# **WATERLOO METRO QUARTER CENTRAL PRECINCT**

## **SSD-10439 - RESPONSE TO SUBMISSIONS DESIGN STATEMENT**

**DPIE RFI - 13/04/2021**

Floor Plan - Level 3-19

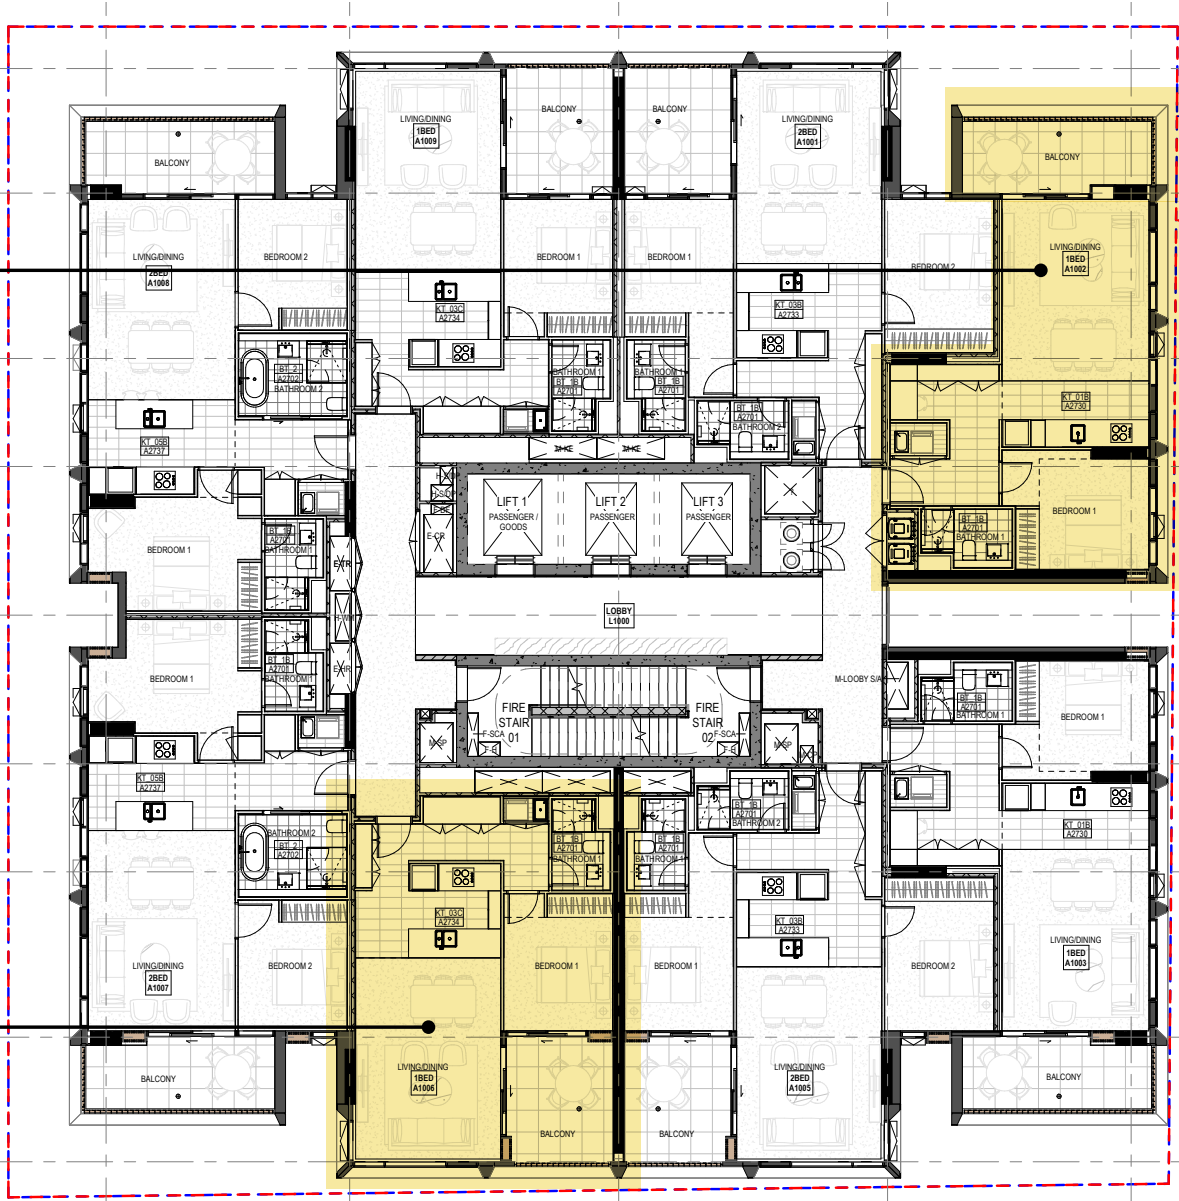
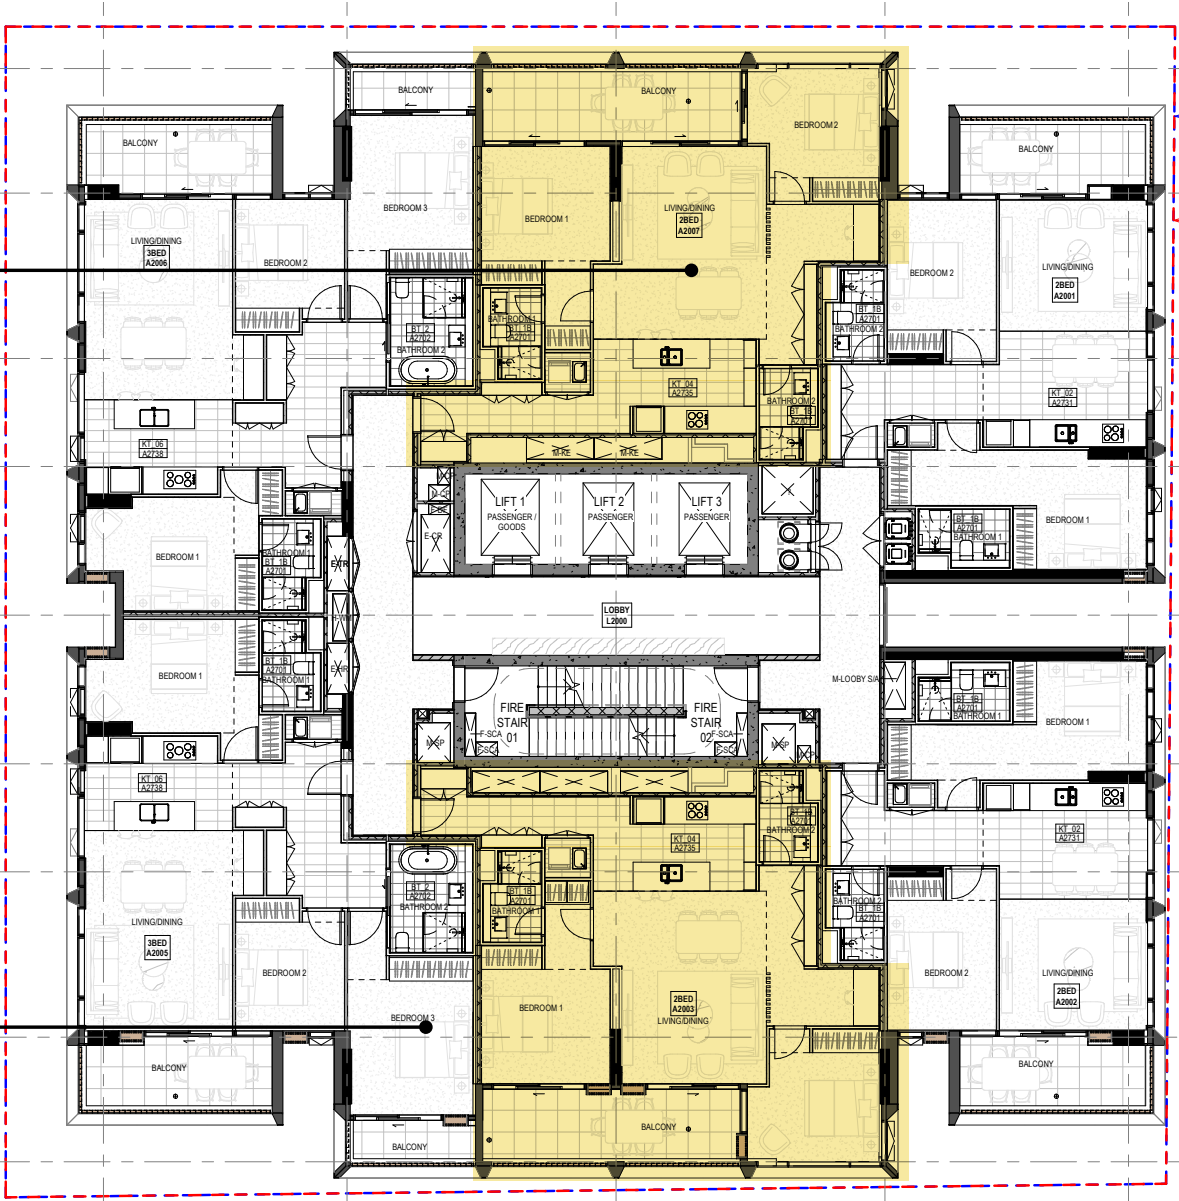
- Minor adjustment to the internal layout of the apartments responding to changes made to the facade.
- Adjacent diagrams outline the design changes to the DA submission.

SOUTH EAST APARTMENT

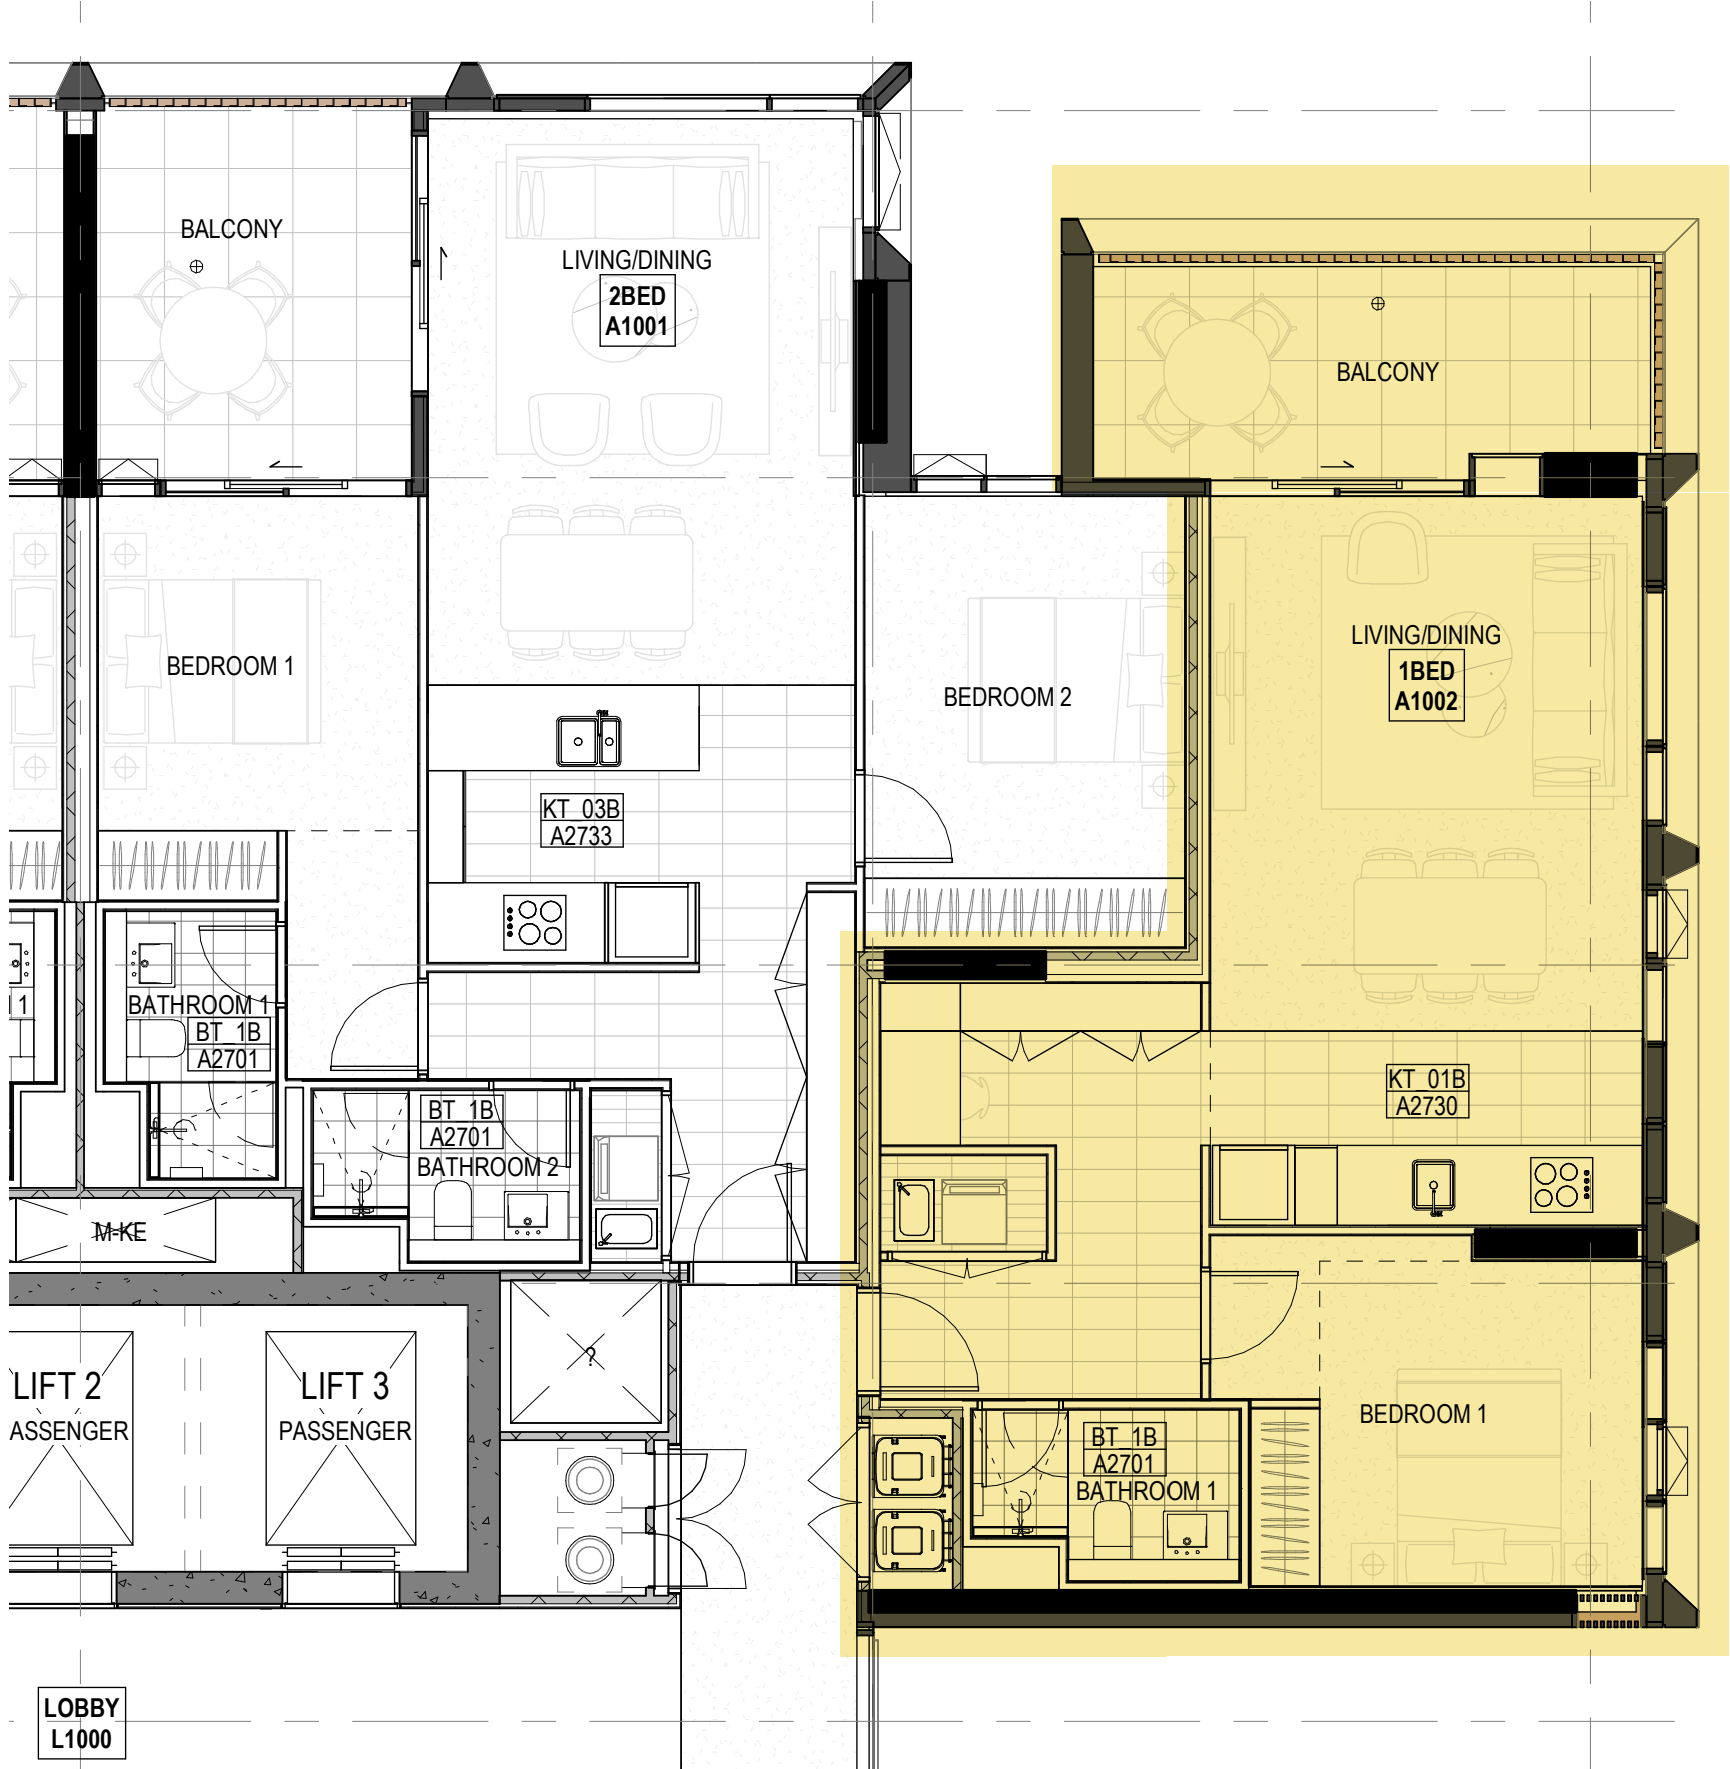
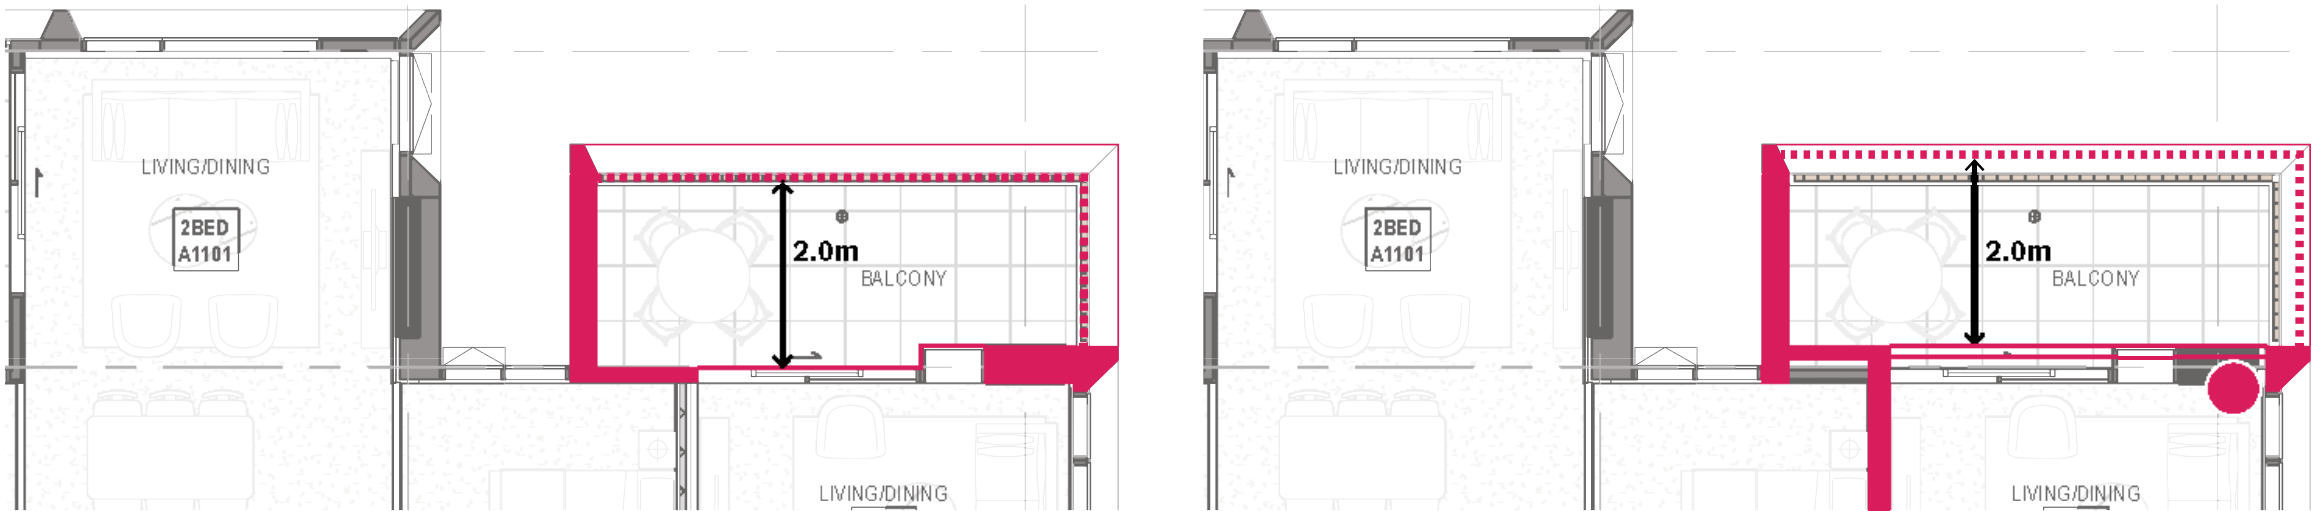
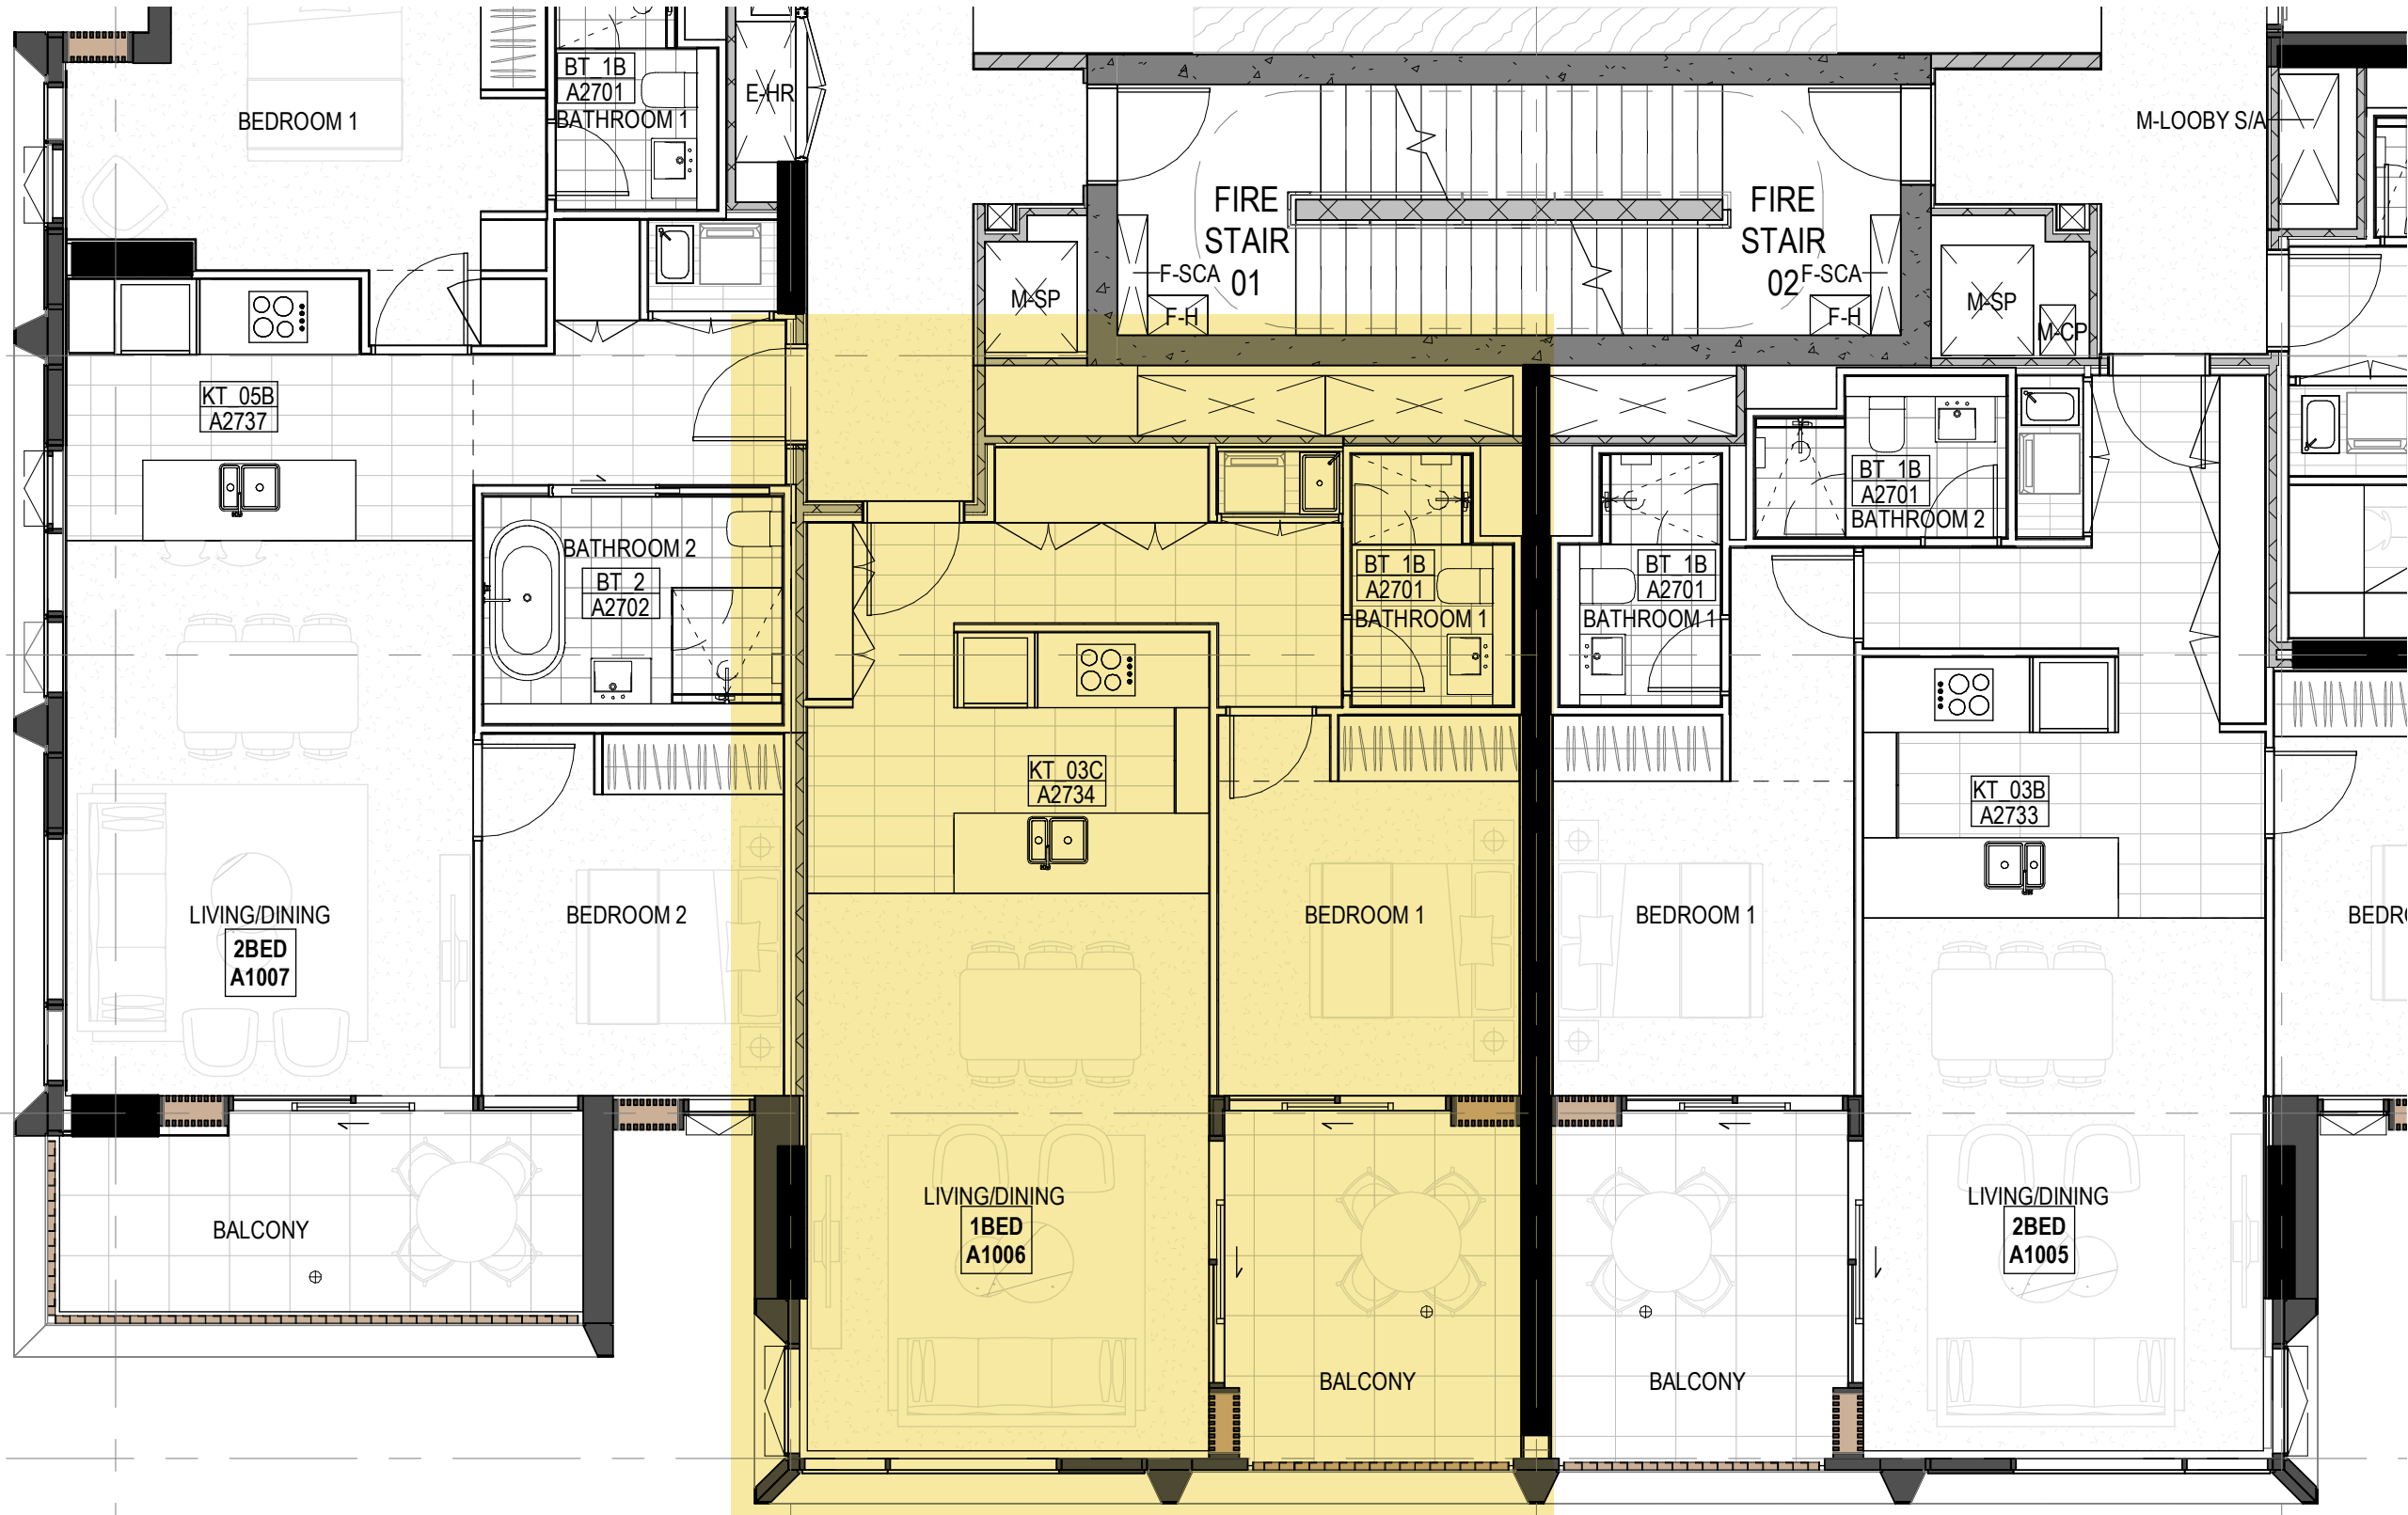
- Shift living room glazing and balustrade east while not creating additional overshadowing to Alexandria Park.
- Reshaping and relocating the south east corner column to be within the apartment.
- To create a consistent architectural language to the building, the proposed design changes to the south east apartment are adopted for all corner apartments.

Glazing and balustrade to move east by 240mm to improve solar amenity of the living room while maintaining the depth required for POS.

Reshape and relocate south east column to be within the apartment to maximise glazing to the living room.

With the above design change, the solar amenity to the living room between level 3 and level 21 are improved by 10mins compared to the DA scheme. The living room window receives more than 1sqm of direct sunlight for 1 hour and 40 mins between 9:00am and 10:40am mid winter.
